**KIRKLEES METROPOLITAN COUNCIL  
INVESTMENT & REGENERATION SERVICE**

**DELEGATED DECISION TO DETERMINE PLANNING APPLICATIONS**

Reference No:	<b>2023/62/93708/E</b>
Site Address:	36, Trueman Avenue, Heckmondwike, WF16 9JX
Description:	Erection of two storey extension to side and dormer window to rear
Recommending Officer:	Elenya Jackson

## **OFFICER REPORT: 2023/93557**

CLIENT	Mr Nazakat Mahmood		
ADDRESS	36 Trueman Avenue, Heckmondwike WF16 9JX		
PROJECT	Proposed		
DRAWING	Proposed Double Story Side Extension With Dormer window		
DRAWN	AS	DATE	Feb.24
DWG No.	131.Arch.2023		
STATUS	Planning

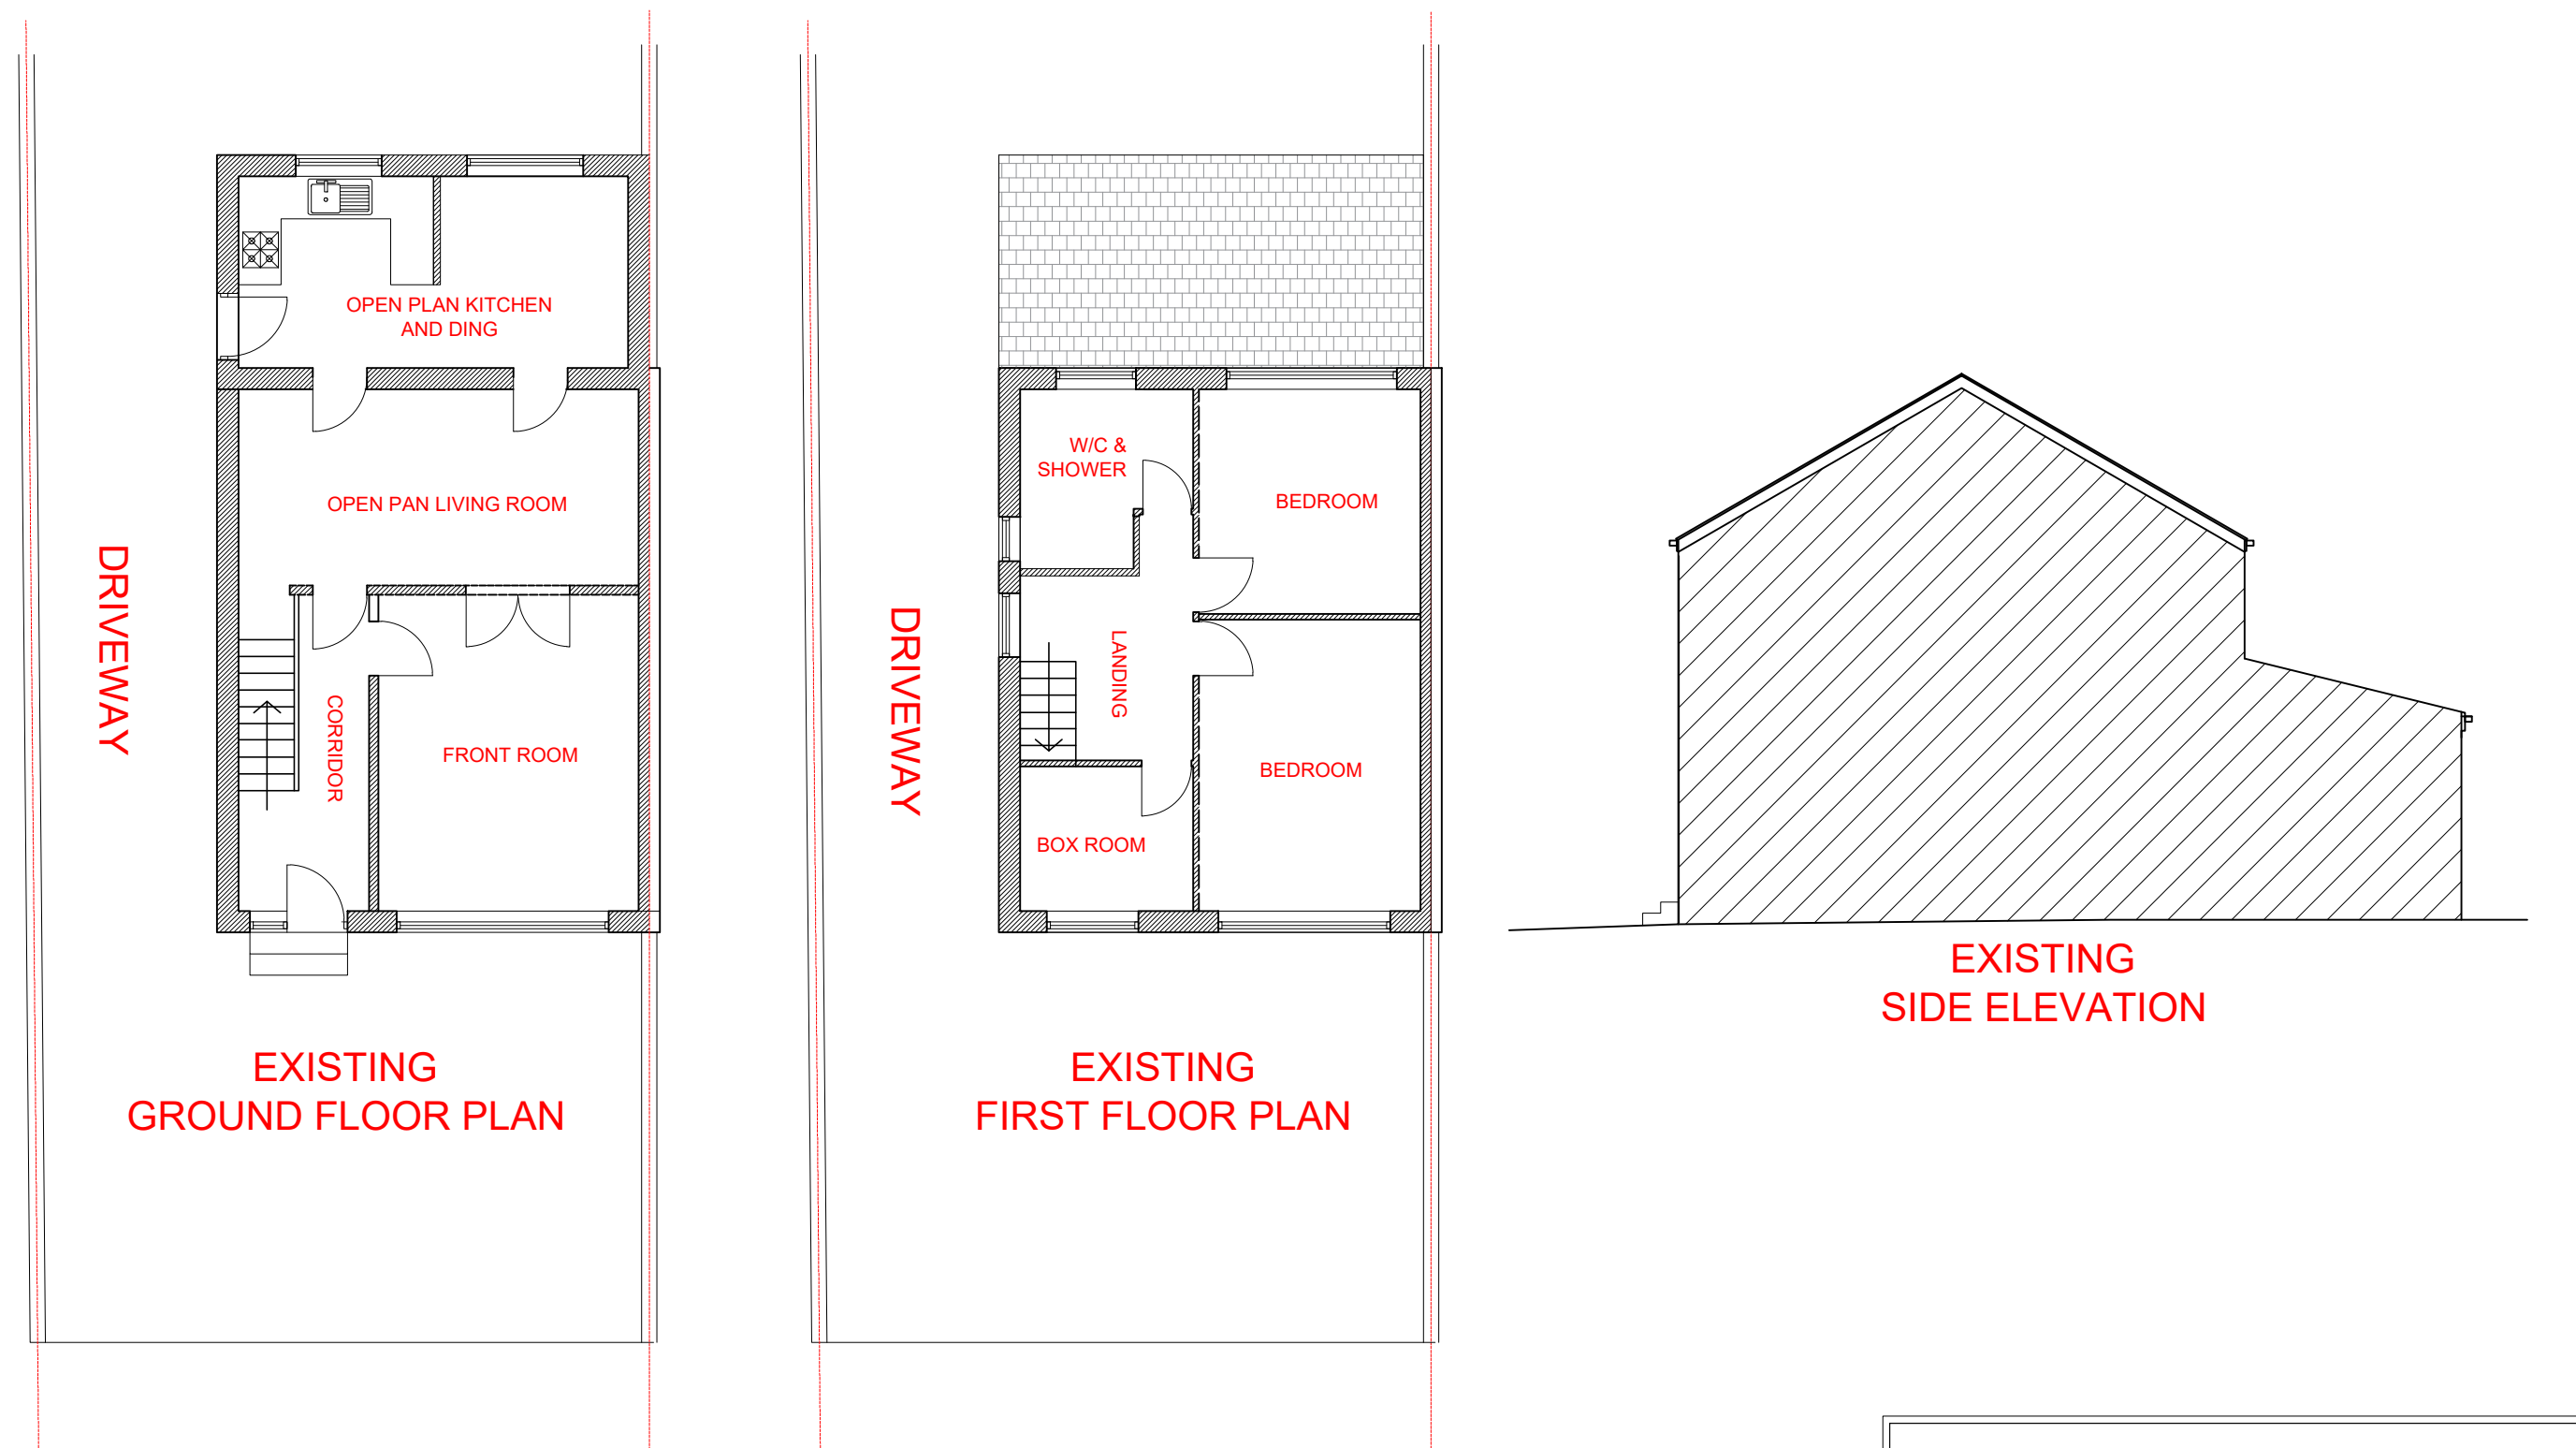
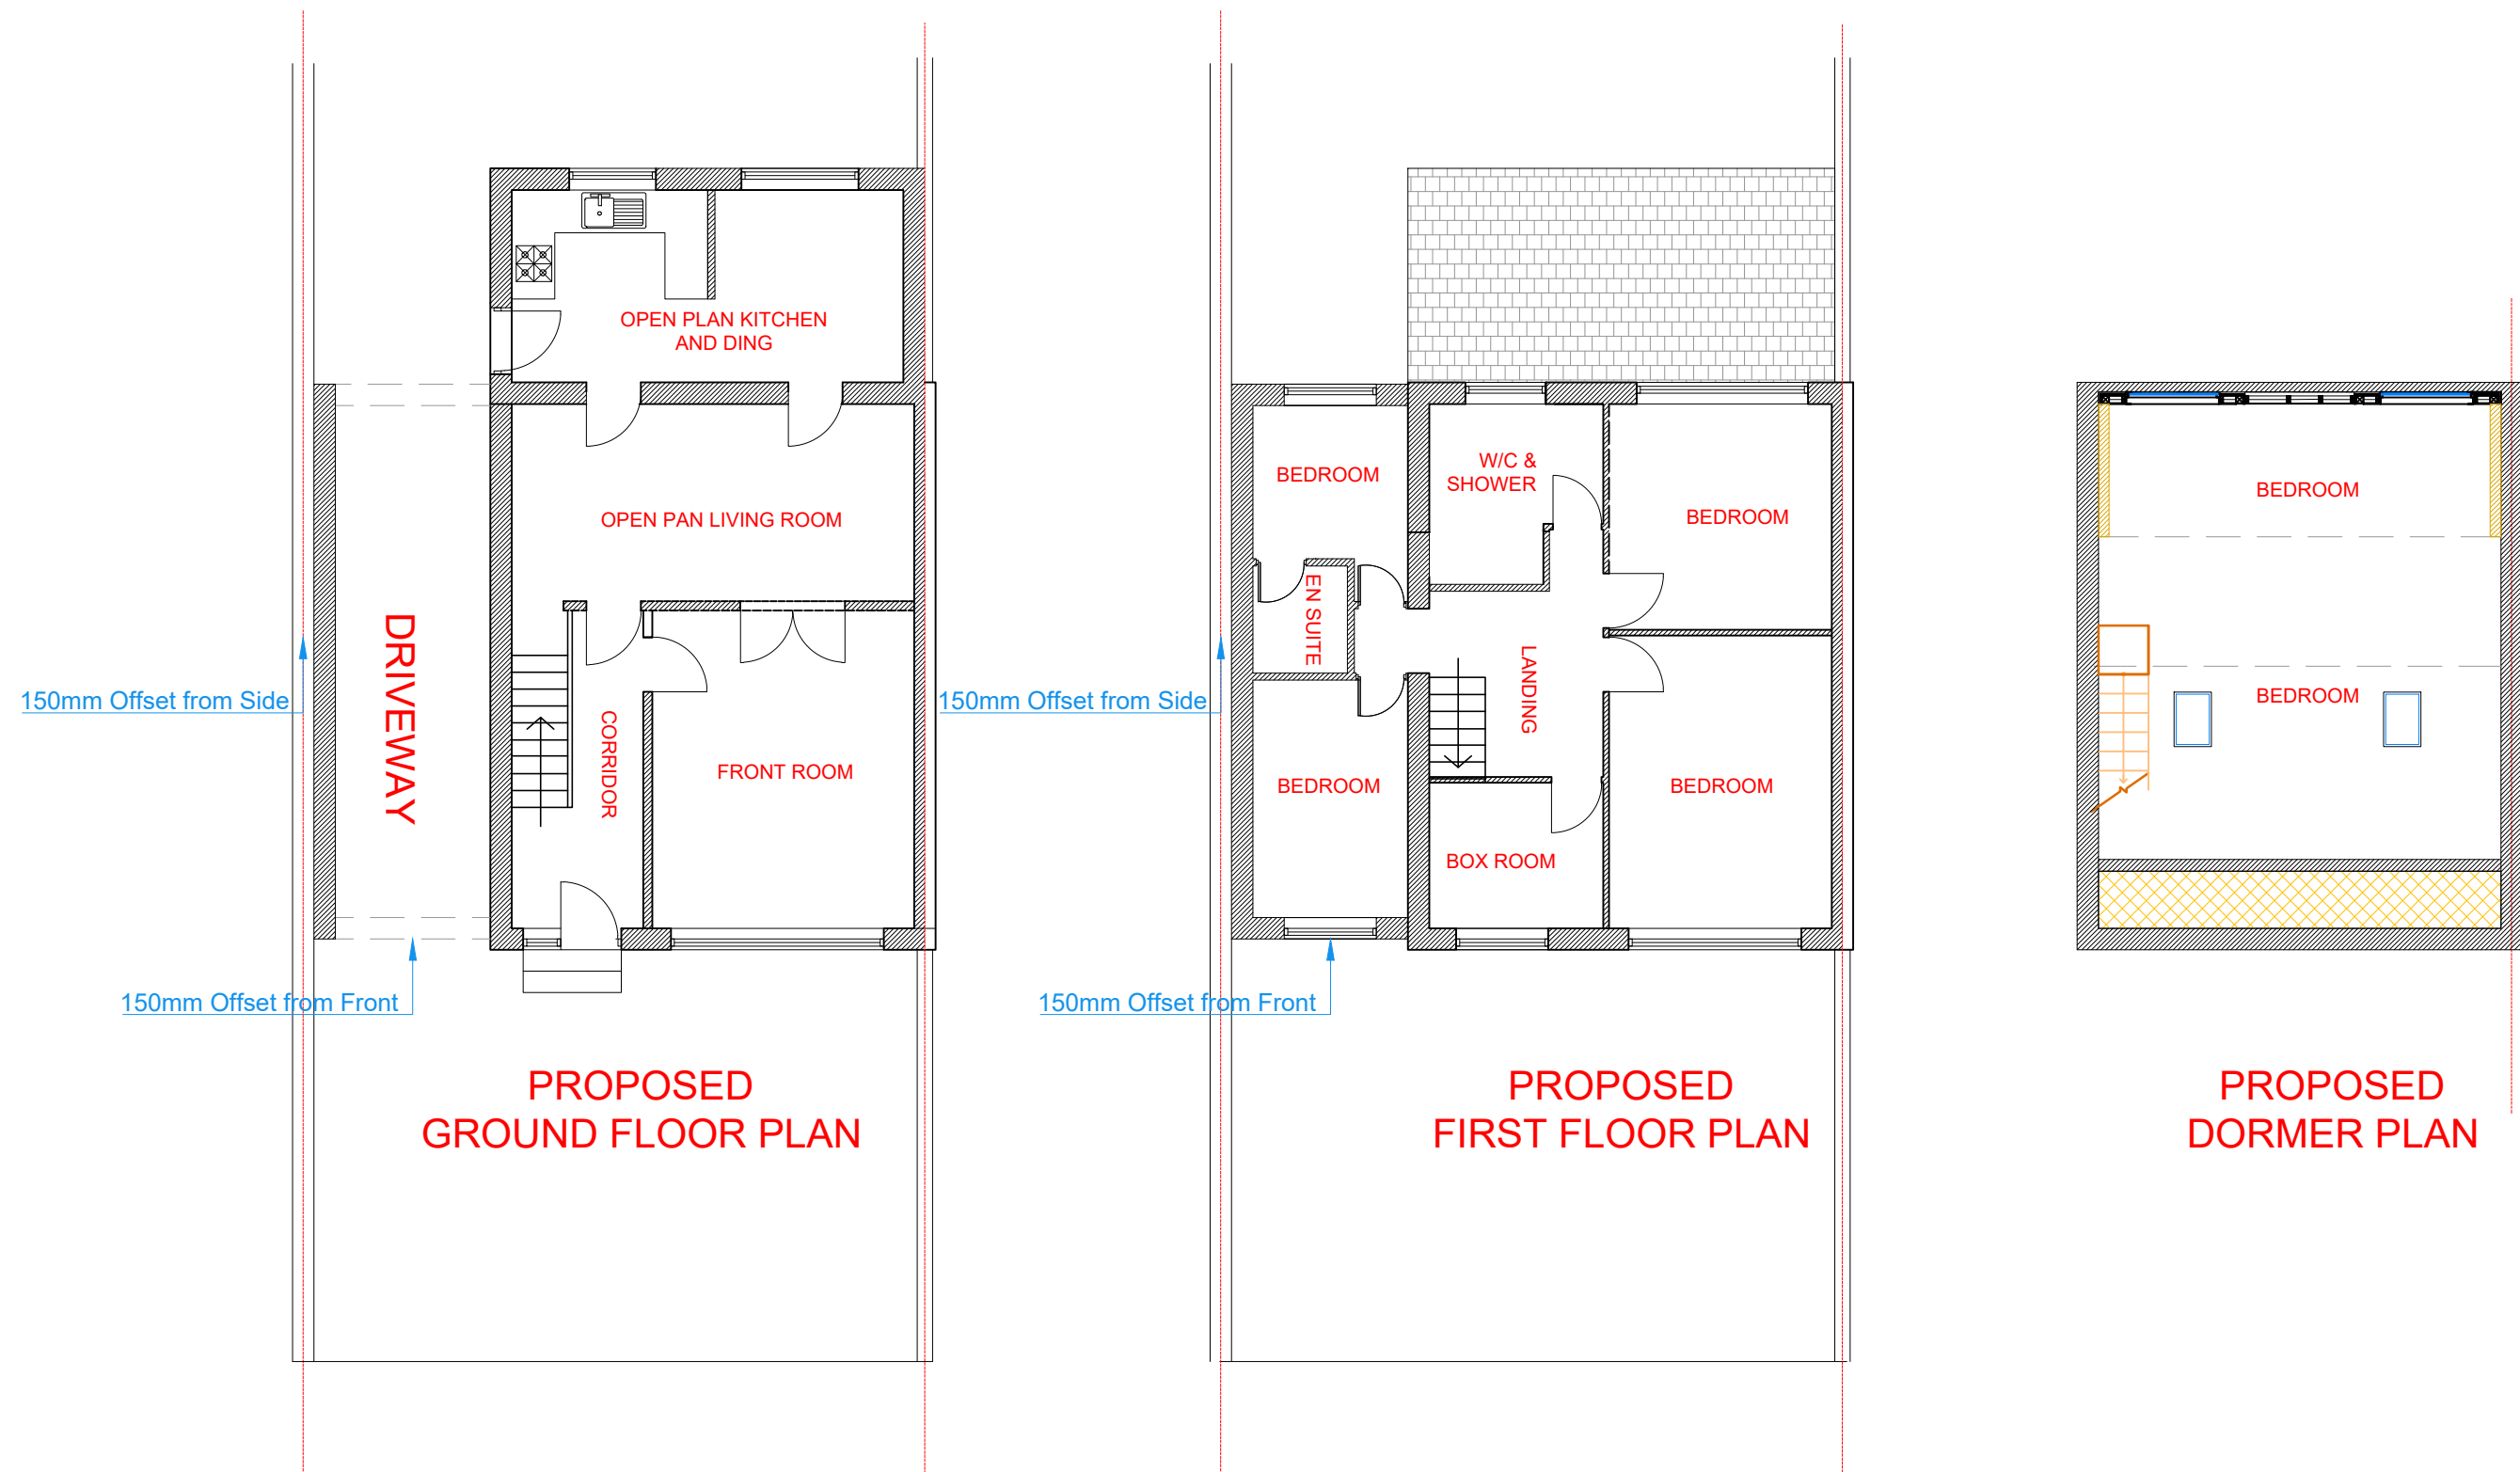
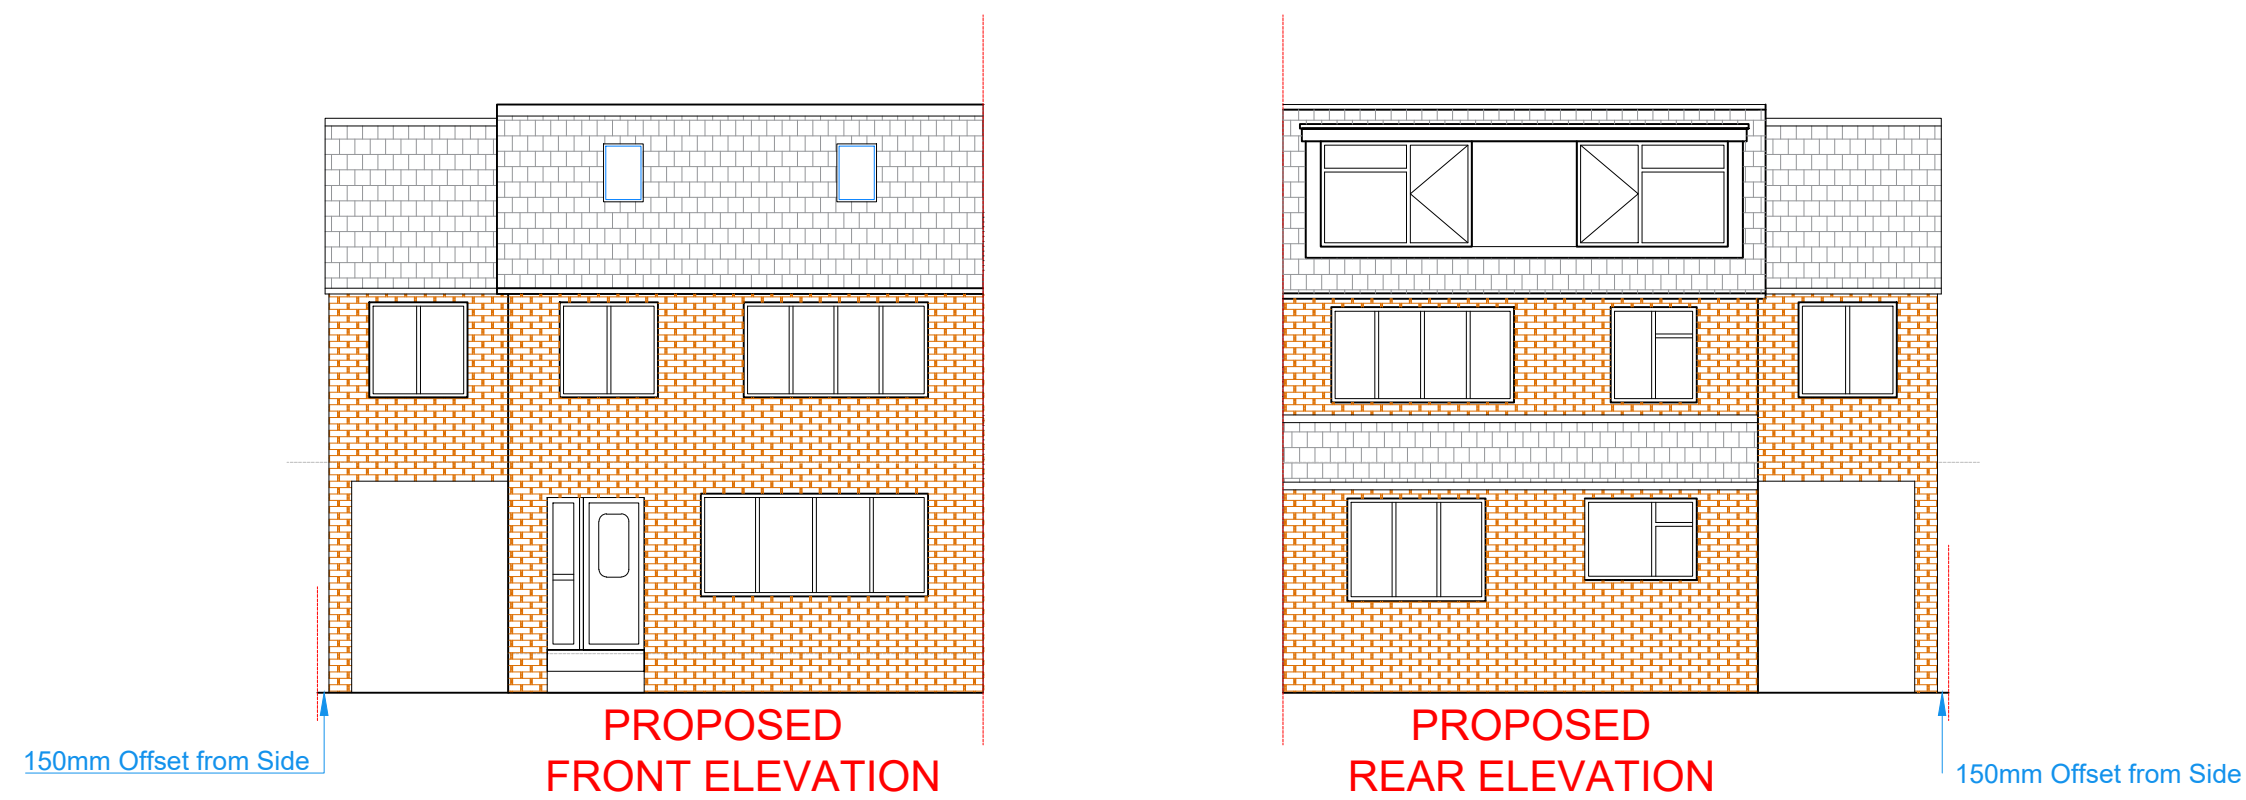
The two storey side extension would extend 2.5m beyond the side elevation of the dwelling and have a depth of 7.8m with a maximum height of 7.6m and an eaves height of 7.4m. This would be set down and back from the host dwelling by 150mm.

The rear dormer would project 3m beyond the roof plane of the host dwelling with an eaves height of 1.8m.

The proposal was initially received with a front dormer which officers requested was removed.

The proposal would be set down and back from the host dwelling (although not the extent set out within the SPD) and due to the spacing provided at the side of the dwelling would be of limited width in the context of the host dwelling. It is acknowledged that the proposal would not allow for 1m gap, nor would be set back by 500mm from the front elevation of the host dwelling, however from a visual perspective, it is considered that the proposal would not appear dominant to the host dwelling. In addition, the applicant has removed the front dormer from the proposal.

The rear dormer would not be overly prominent from the public realm, would be contained within the roof space of the host dwelling and constructed out of matching materials.

*Impact on 38 Trueman Avenue:* adjoins the application site to the east.  
Overlooking: The proposal would not feature any side facing windows and therefore would not result in a loss of privacy to the occupants of no.38.  
Overshadowing/loss of light/overbearing: The proposed extension would be located to the south west of no.38, would not increase the maximum height of the dwelling or extend beyond the principal or rear elevations of the dwelling. The proposal also would not be situated within the vertical 45 degree visibility splay of any windows at no.38. In addition, No.38 is elevated in relation to the

Overlooking: The dormer would be contained within the roof space of the host dwelling and the two storey extension would be screened by the host dwelling. Therefore no significant issues would arise regarding the residential amenity of the occupiers of no.34.
